**Merimbula Sewage Treatment Plant Upgrade and Ocean Outfall (SSI-7614)
Environmental Impact Statement**

Liz Rogers
Manager, Assessments, Knowledge Division
Department of Planning, Industry and Environment: Water
24 September 2021

Detailed advice to DPIE Planning & Assessment regarding the Merimbula Sewage Treatment Plant Upgrade and Ocean Outfall (SSI-7614) - Environmental Impact Statement

FIGURE 2-3: OCEAN OUTFALL PIPELINE - SECTION 1 (BELOW GROUND)

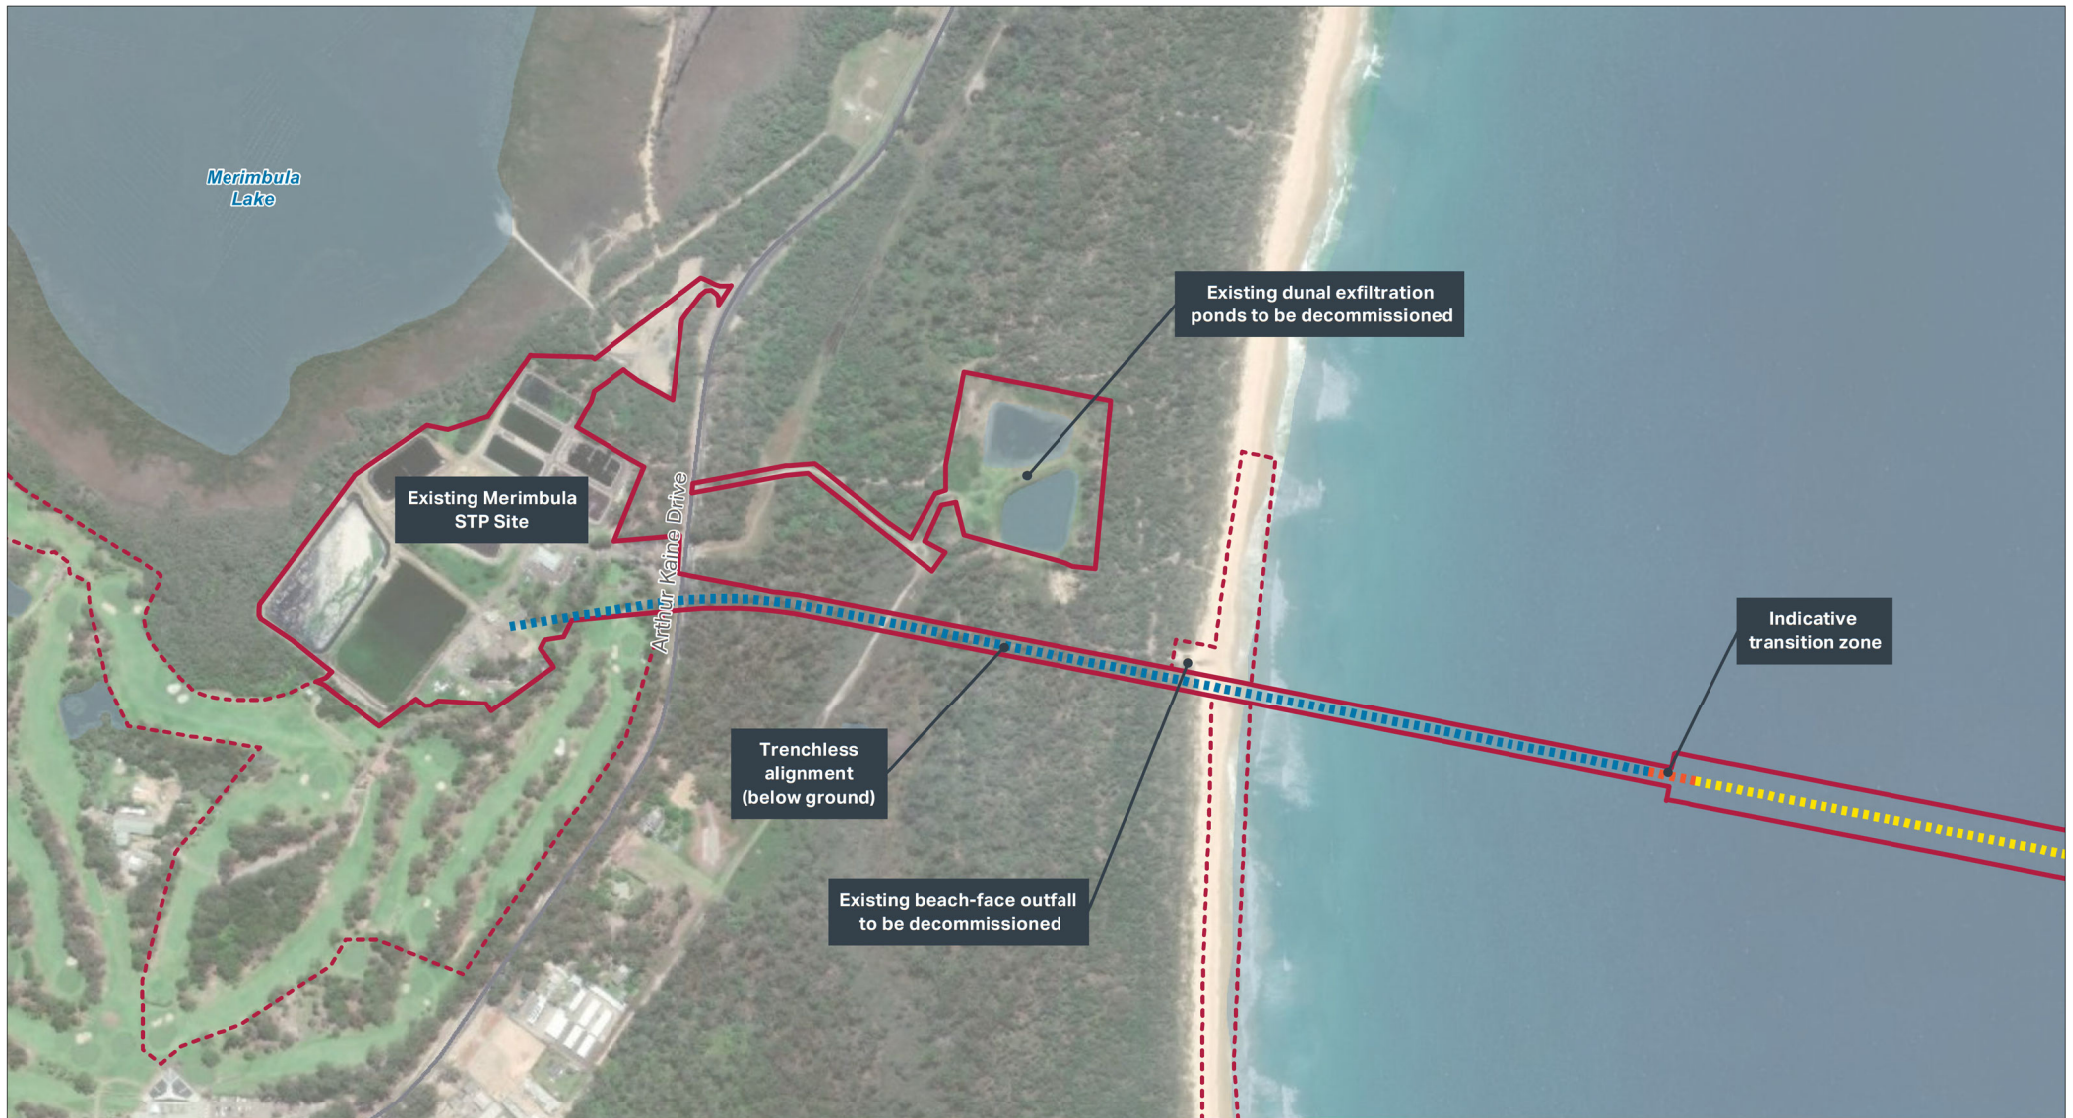
There will be water inflows into the tunnel for the pipeline. This is likely to be minor however DPIE Water would like to see an estimate of the water take. No licence is required if the take is less than 3 ML as specified in *Schedule 4 Part 1 exemptions* in the *Water Management (General) Regulation 2018*.

DPIE Water notes that the construction processes, specifically relating to the pipeline construction, are not yet confirmed. DPIE Water requires additional clarification regarding the processes to give confidence in the assertions that dewatering '*would be seawater / marine (saline) groundwater, and therefore impacts to terrestrial (fresh or saline) groundwater are unlikely (as water pumping would occur from the seaward side of the salt-water wedge*' (EIS, 2021).

DPIE Water acknowledges that dewatering volumes will potentially be small, and that the water may be extracted from the marine-side of the saltwater wedge, however, to improve DPIE Water's confidence in the proponent's assessment, the predicted take should be quantified and the potential impacts suitably demonstrated.

- Provide a quantified prediction (using analytical methodology) of any potential groundwater take related to the project, from the 'intermediate drilling site' or otherwise.
- Indicate predicted drawdown impacts and location of any proposed dewatering, in relation to the marine water-groundwater demarcation, in a conceptual model cross-section.
